## STOP LIME DOWN

## HERITAGE AND ARCHAEOLOGY REPSONSE

April 2026

Title:
Figure 12-2-3: Archaeological Assets:
Lime Down Lime Down C

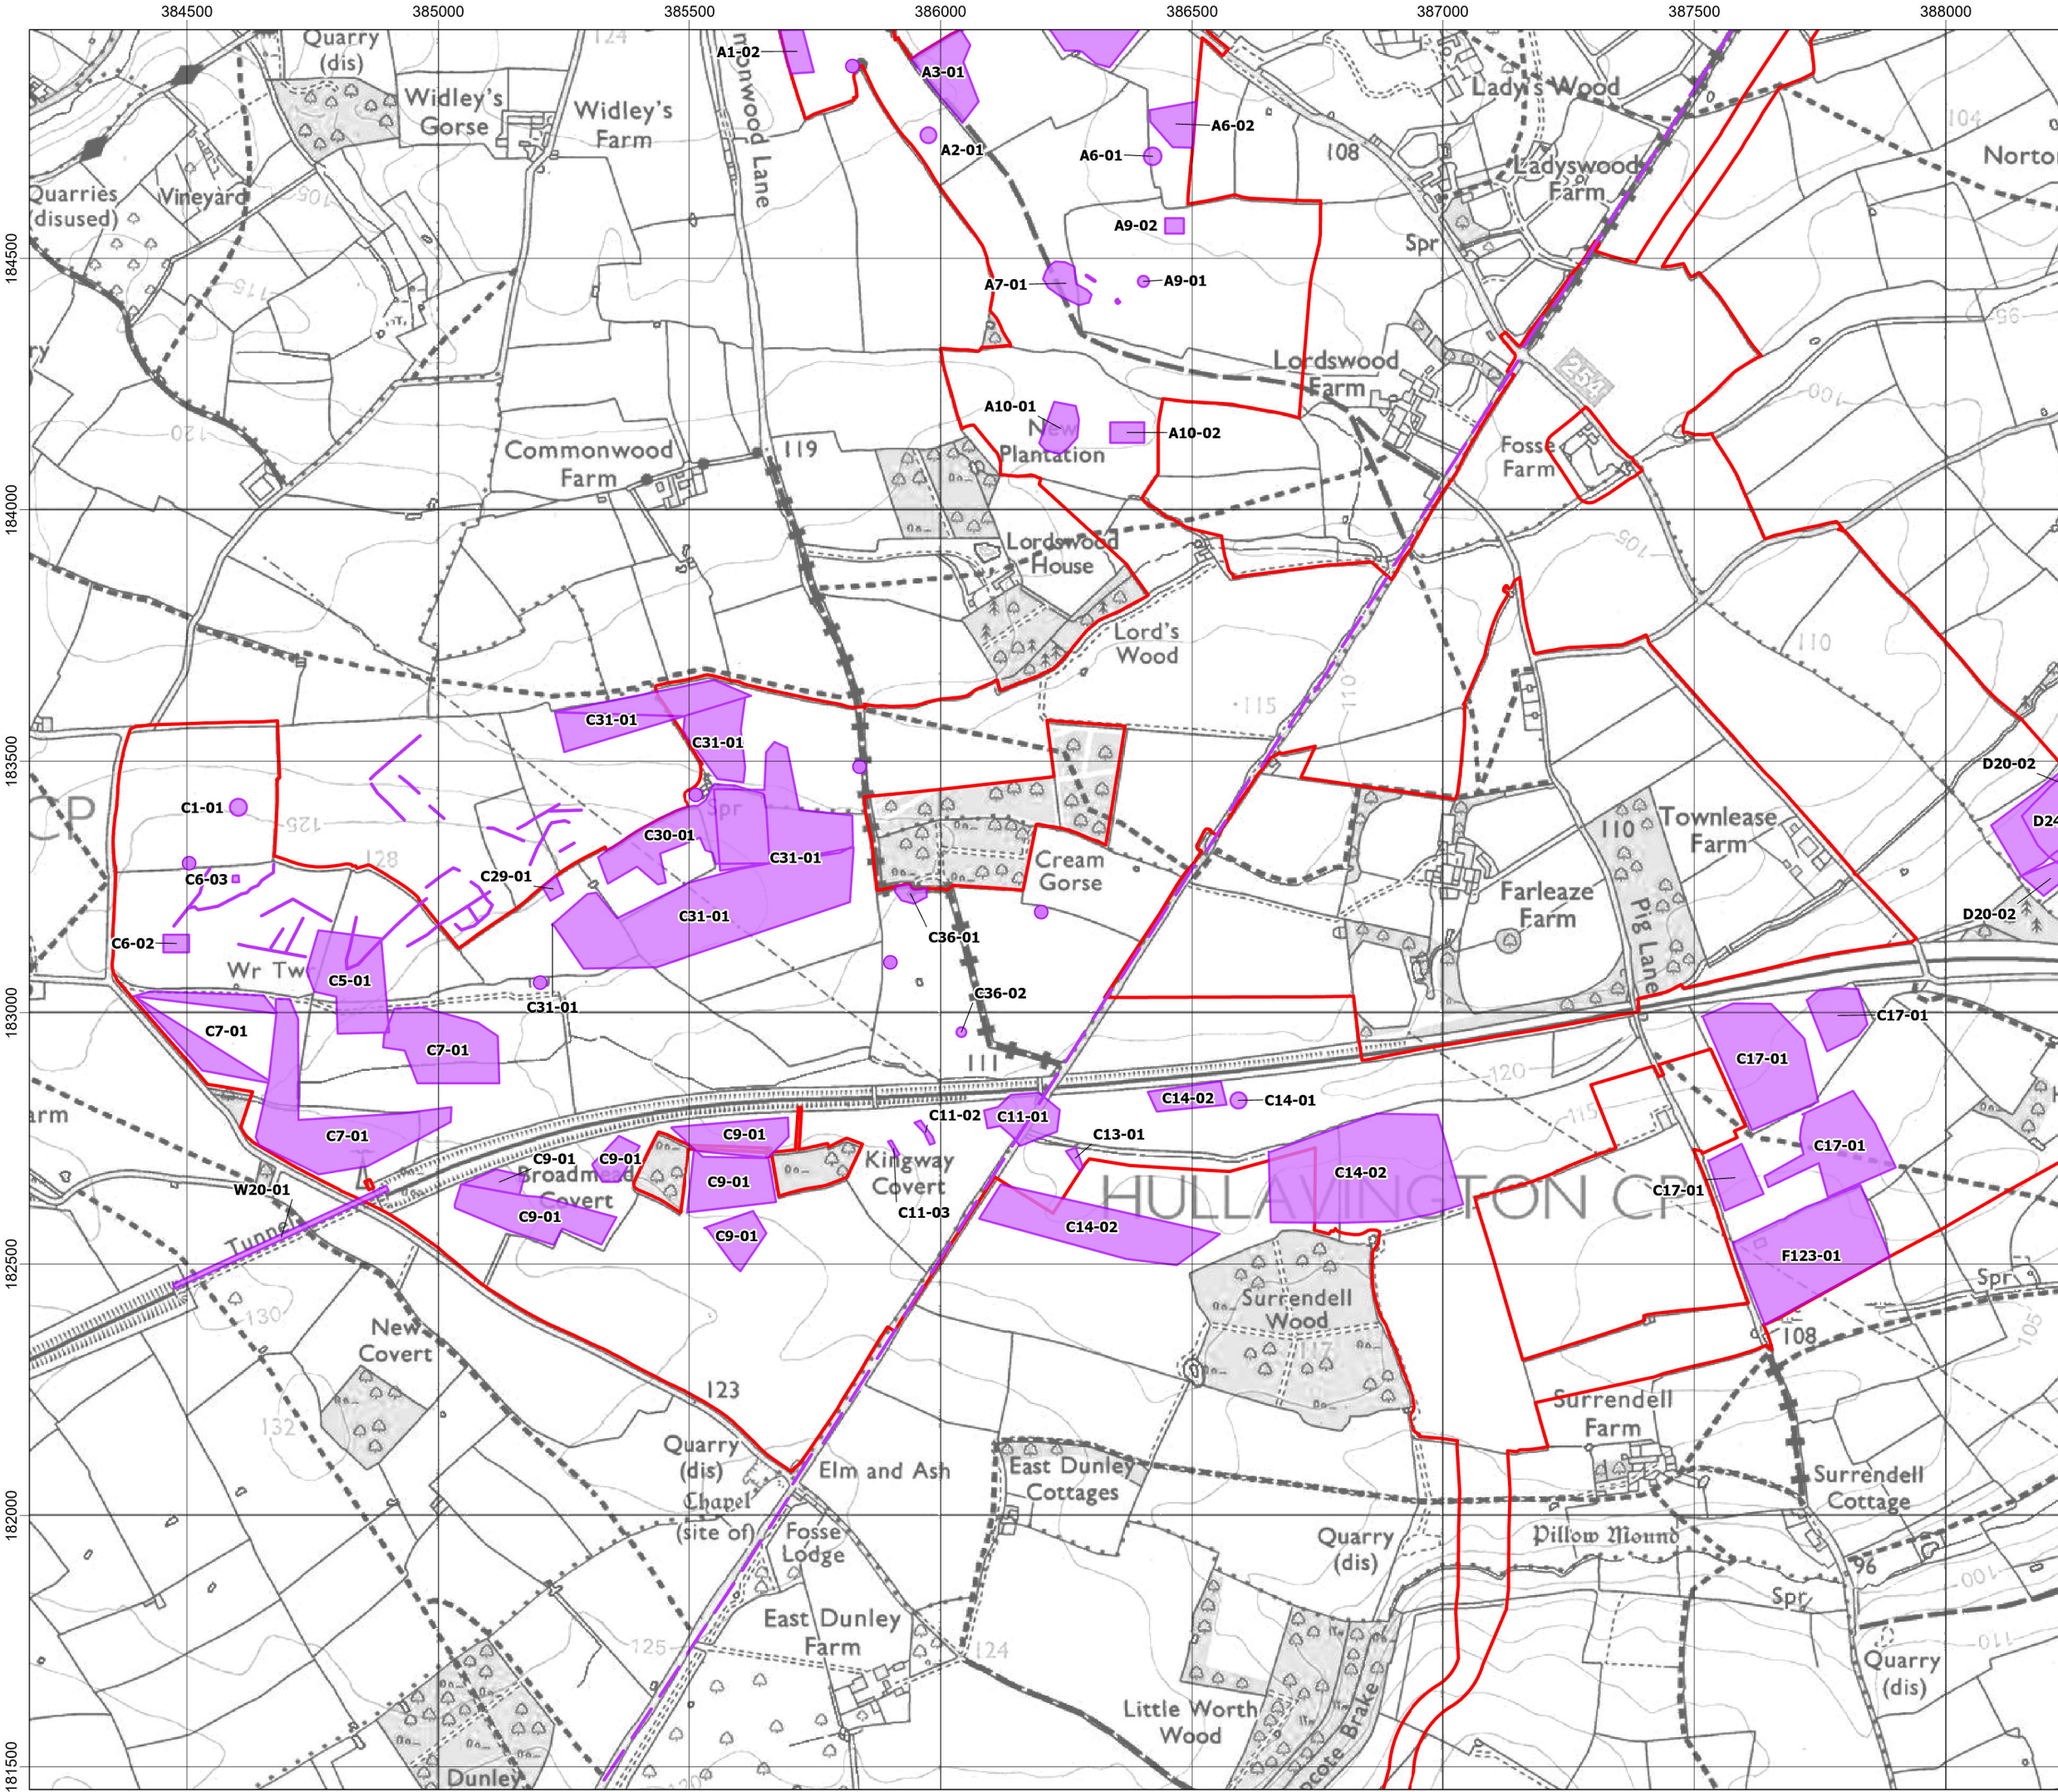
- 2.12 Archaeological constraints of Lime Down C include potential Roman settlement sites identified through geophysical survey [APP-223] and trial trenching [APP-225] to APP-229], which share a close association with the Fosse Way Roman Road, a nationally significant (although not scheduled) Roman routeway which passes through the centre of the works area, which could be of equivalent significance to a Scheduled Monument and thus, in line with paragraph 5.9.8 of EN-1, subject to the policies for designated heritage assets, as discussed in paragraph 3.6 – 3.9. of this report. We consider that the Applicant has failed to adequately assess the impact of the scheme on the relationship between possible Romano-British settlement sites and the Fosse Way, as well as the impact of landscape and ecology planting on buried remains within this works area.

Title:
Figure 12-2-5: Archaeological Assets:
Lime Down Lime Down E

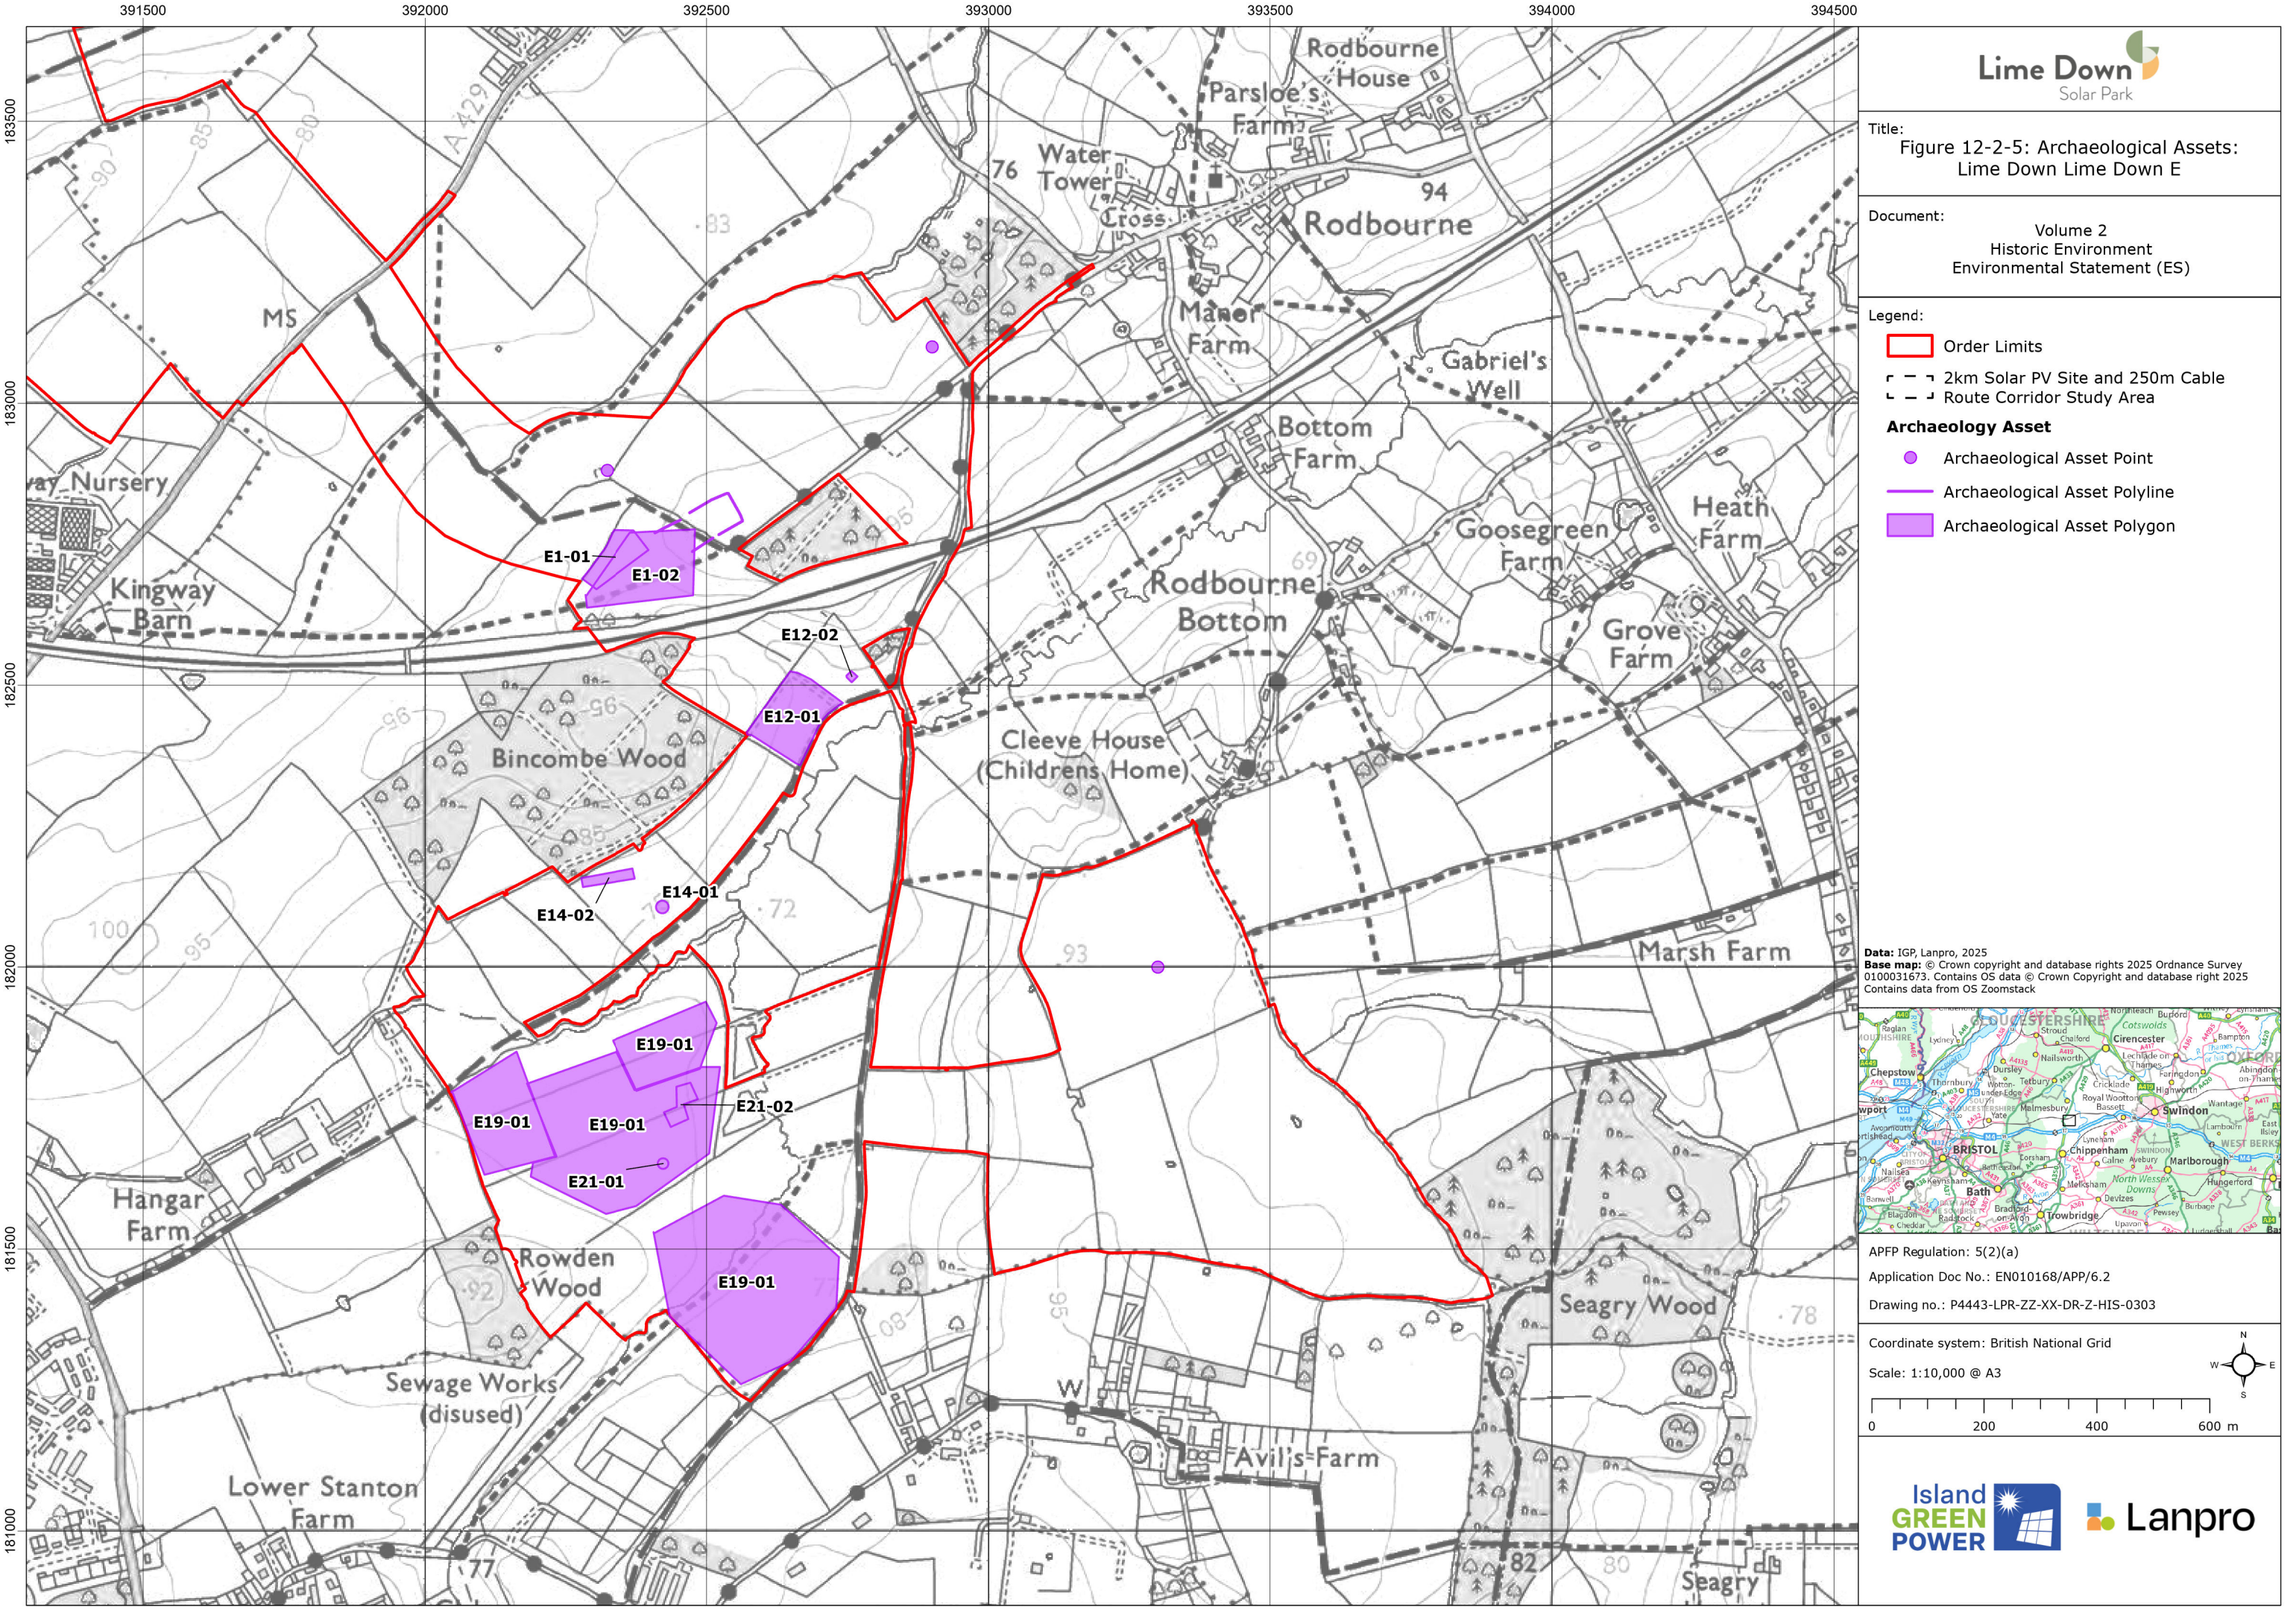
- 2.18 Archaeological constraints of Lime Down E include potential Prehistoric and Roman settlement sites identified through geophysical survey [APP-223] and trial trenching [APP-225] to [APP-229]. We consider that the Applicant has failed to adequately assess the impact of the scheme on the relationship between possible Romano-British settlement sites and the Fosse Way, as well as the impact of landscape and ecology planting on buried remains within this works area.
